From: Alfred Yeatman [REDACTED]
Sent: 25 August 2017 10:26
To: Simon Davis
Cc: Rachel Davies
Subject: RE: P/49/17/DOC Church Farm Holiday Village [NLP-DMS.FID263510]

Following further work to the Church Farm drainage scheme we attach updated drawings and associated calculations.

PROJECT No.	DRAWING No.	REV.
J-11399	3401	B

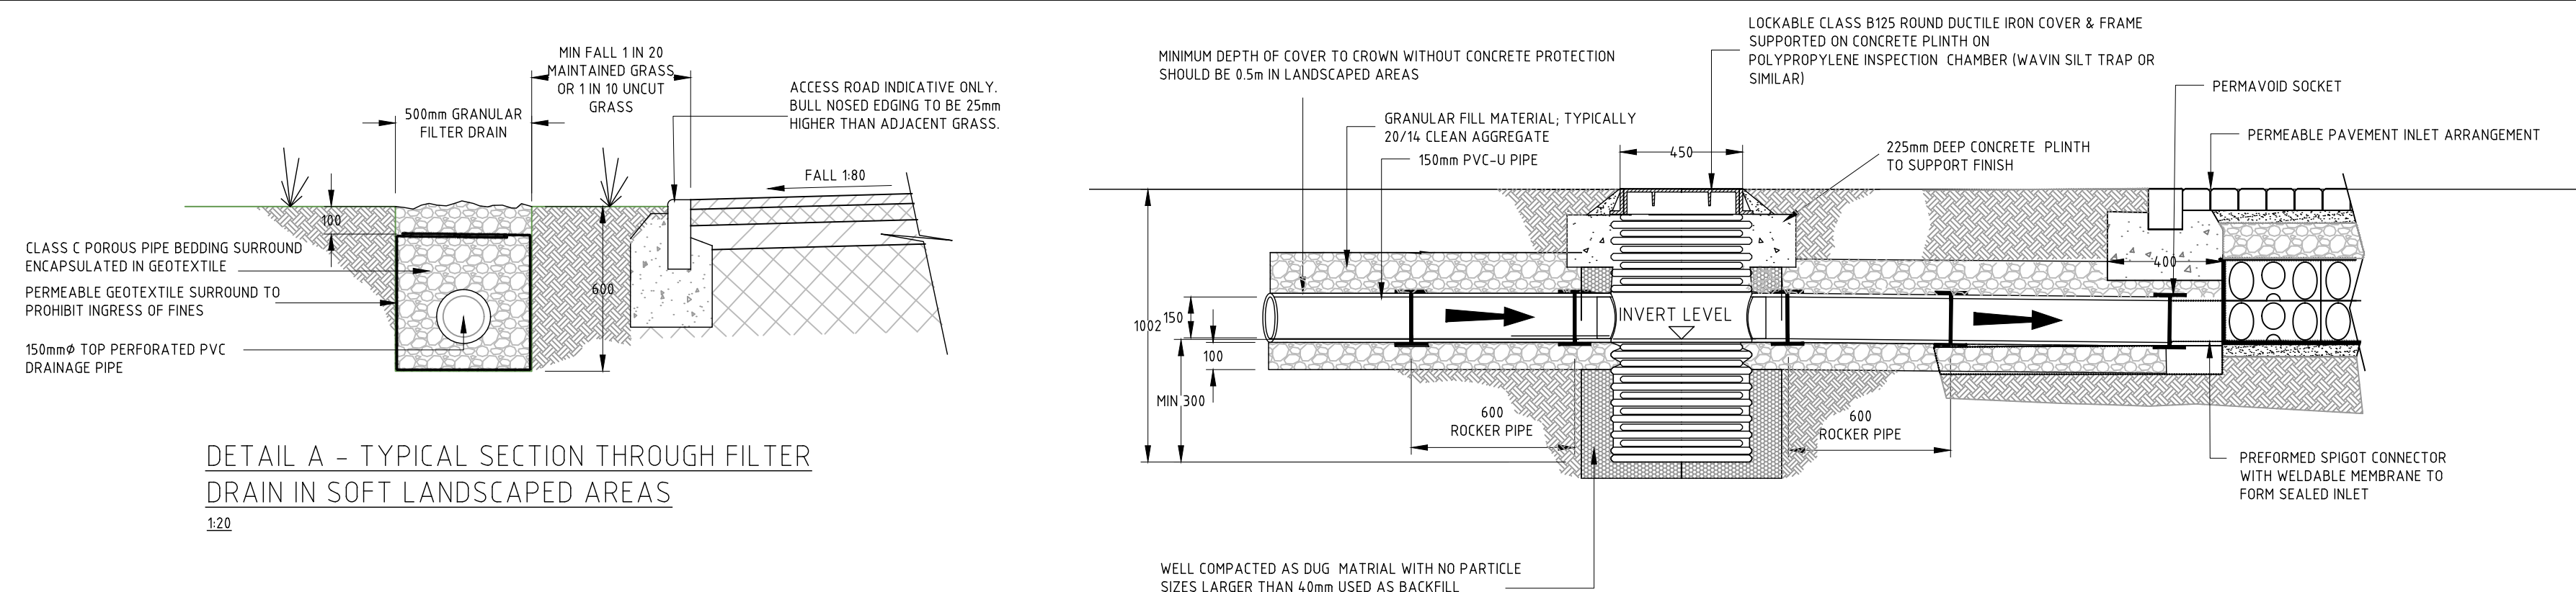
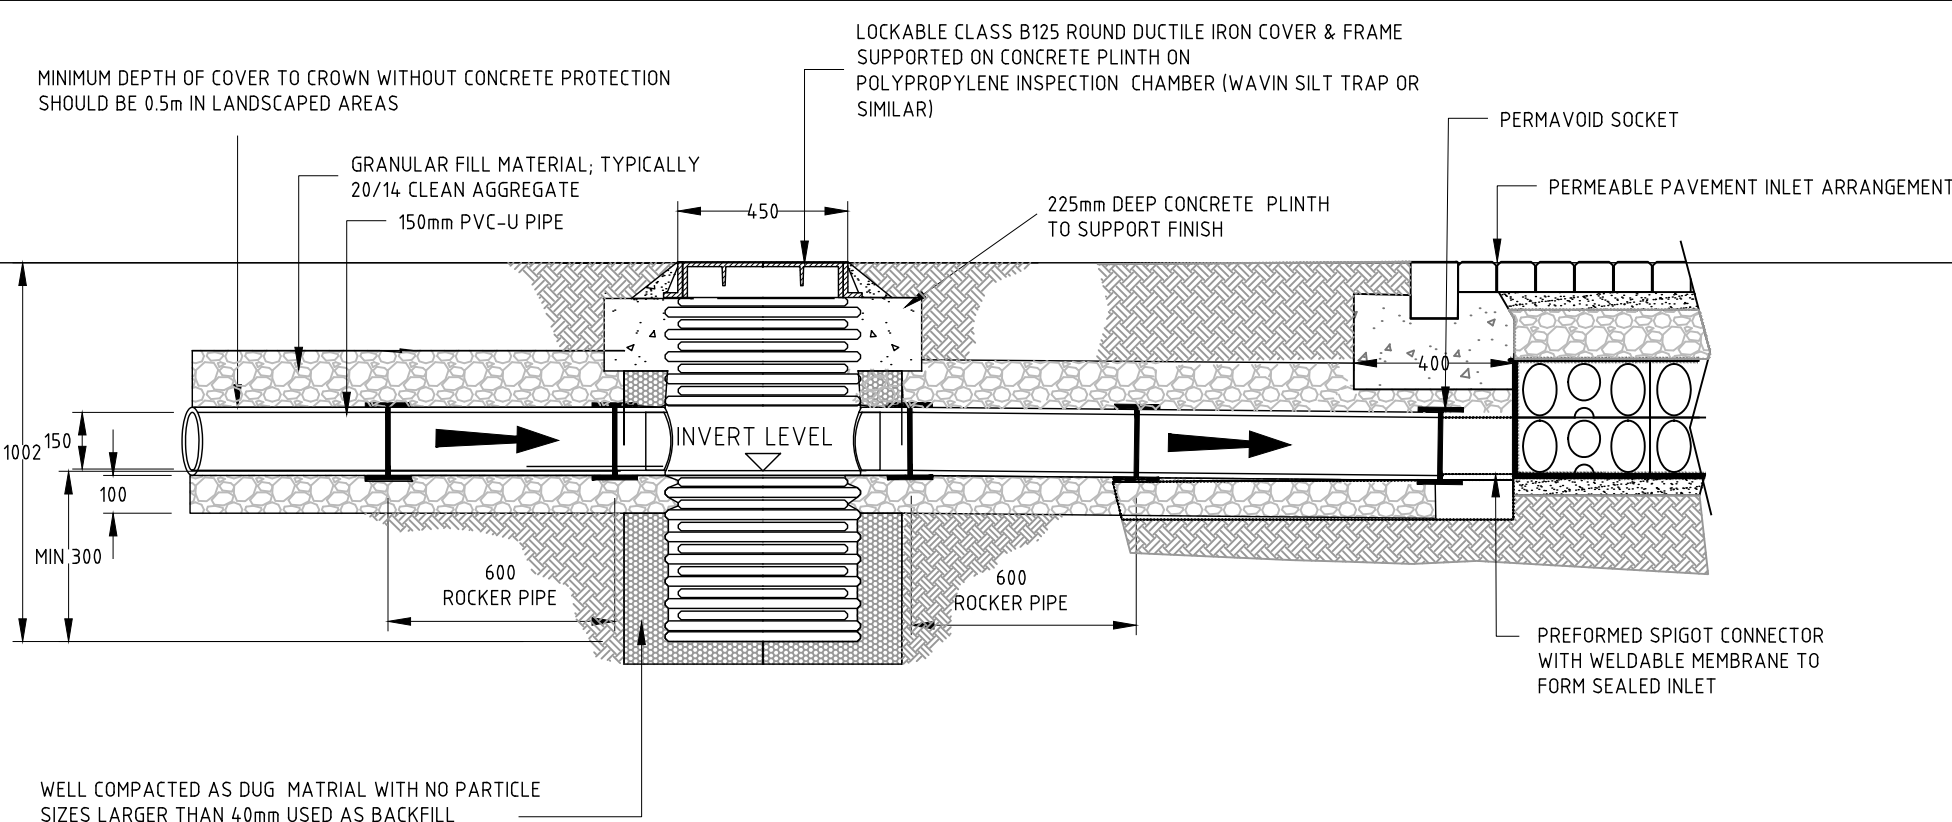
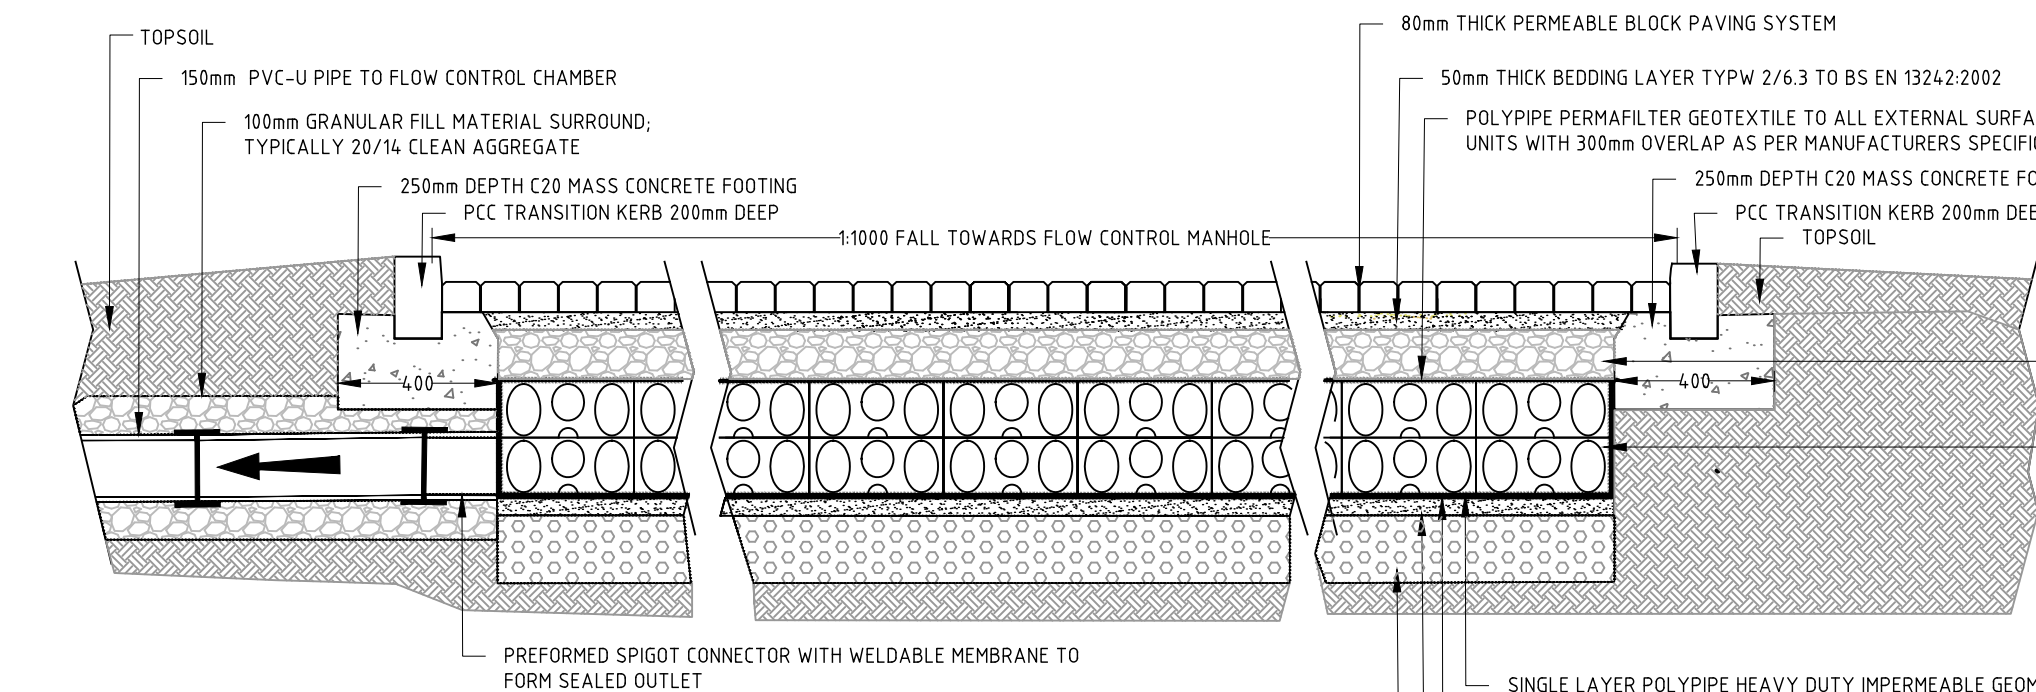
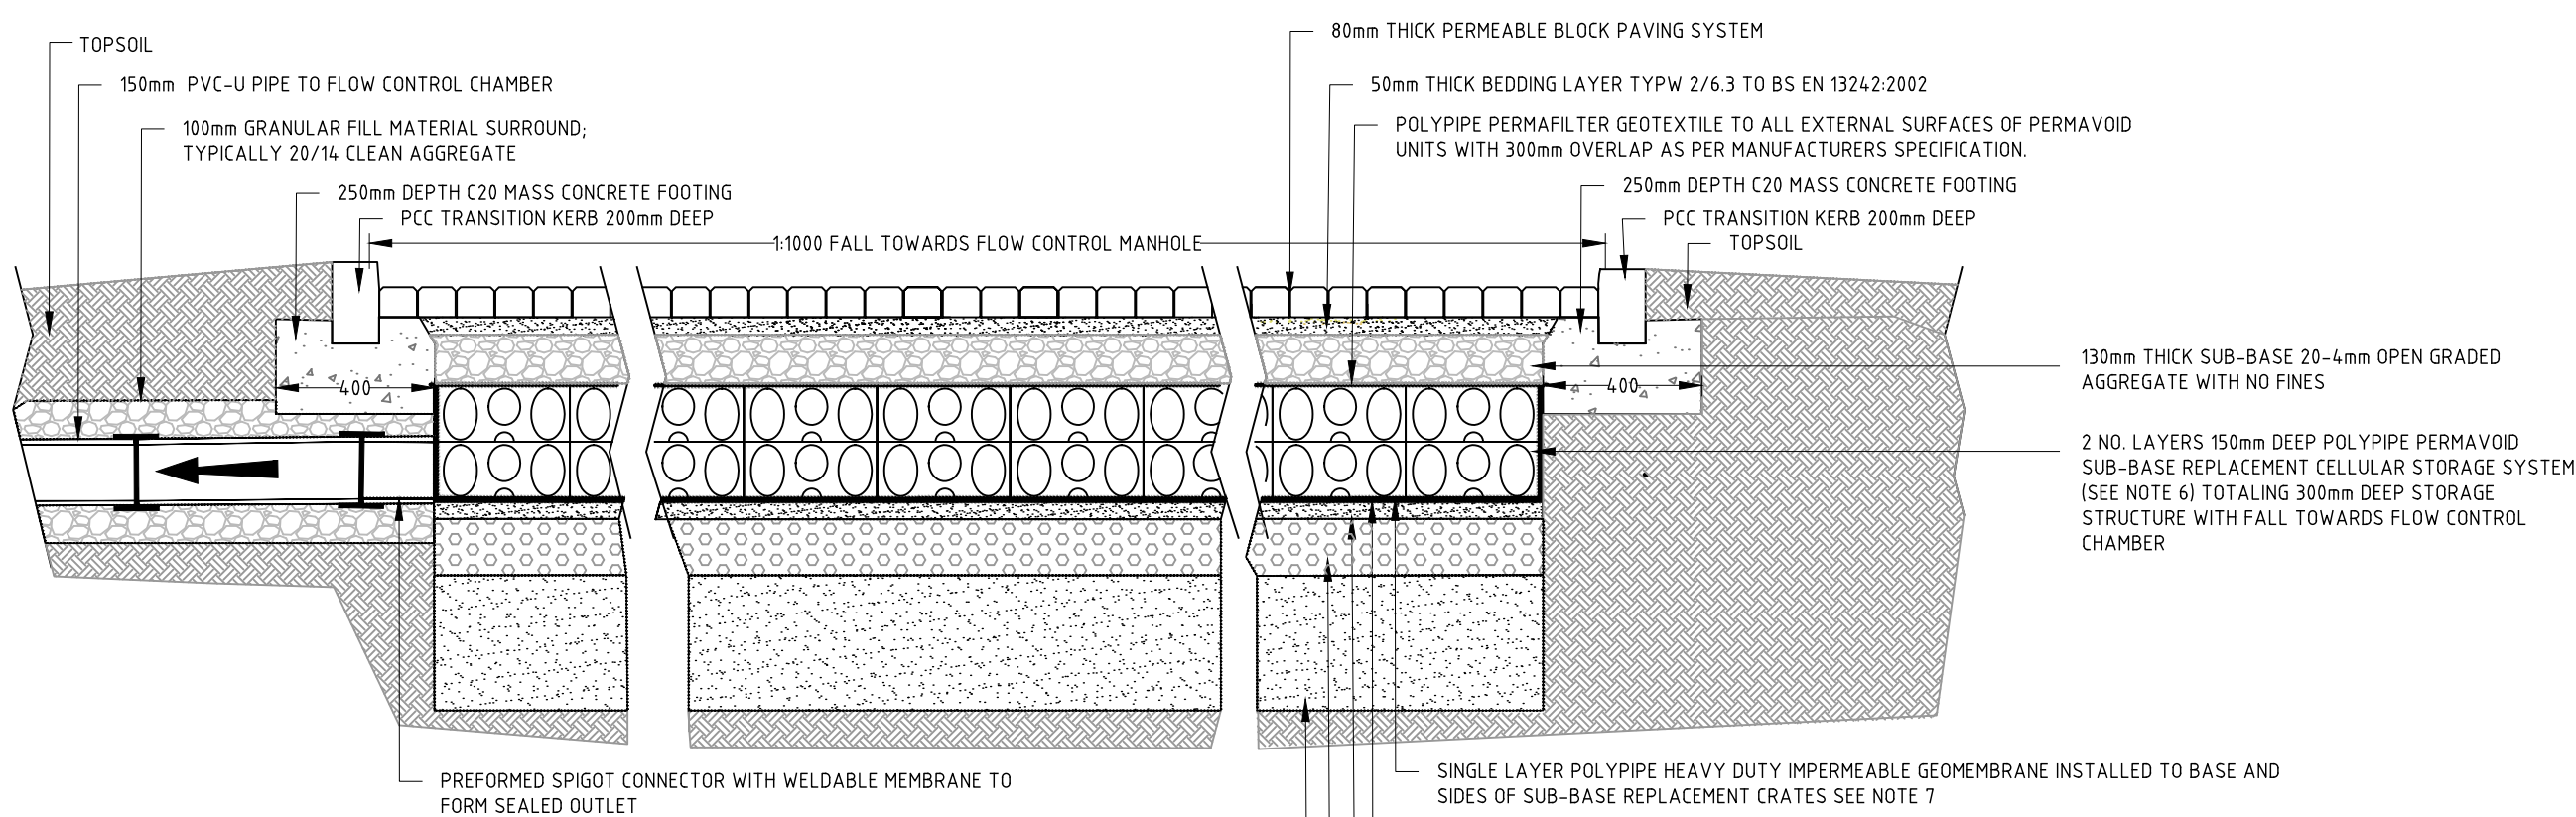
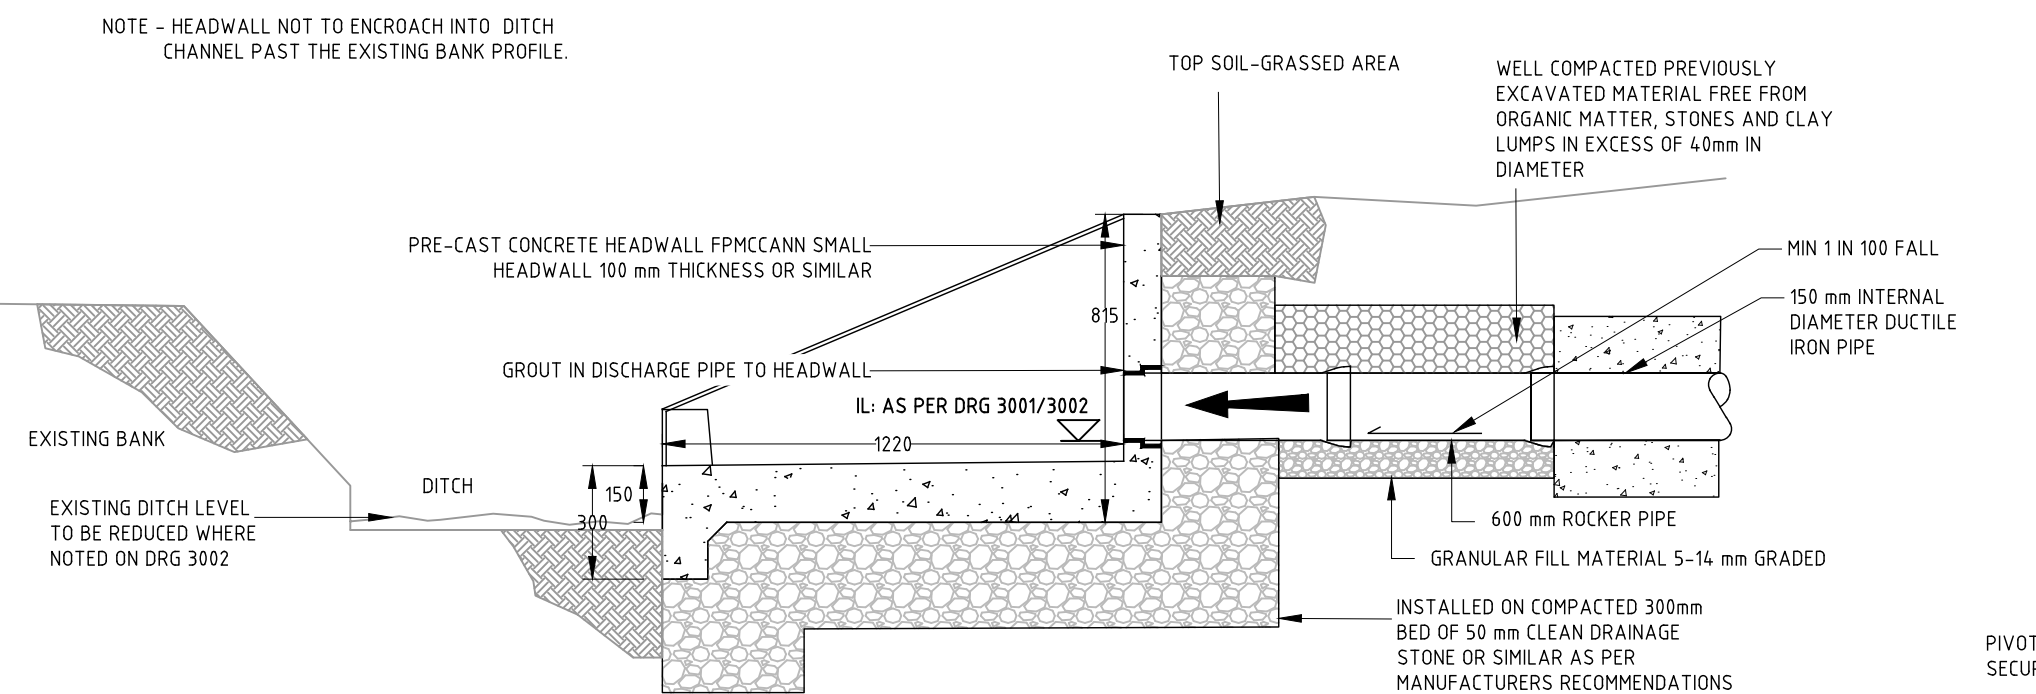
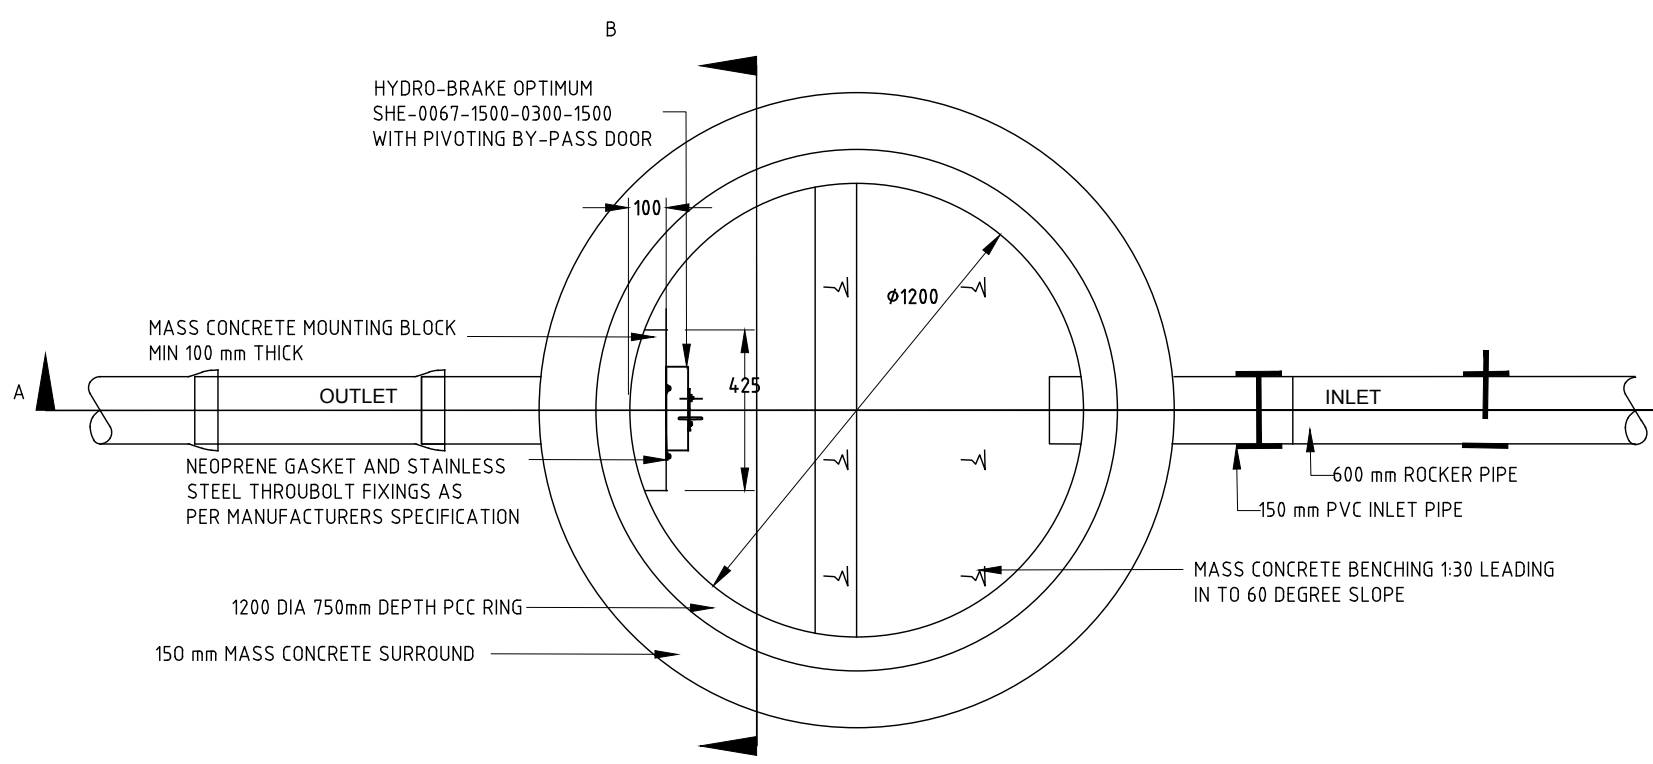
- 8. Provide construction detail drawings for the permeable pavements/flow control chambers/filter drain/filter drain manholes (silt traps)/headwalls/pipe inlet arrangement to permeable pavements/pipe bedding & pipe spec for outlet pipes/raised flood attenuation kerbing. **See drawing 3401 for details.***
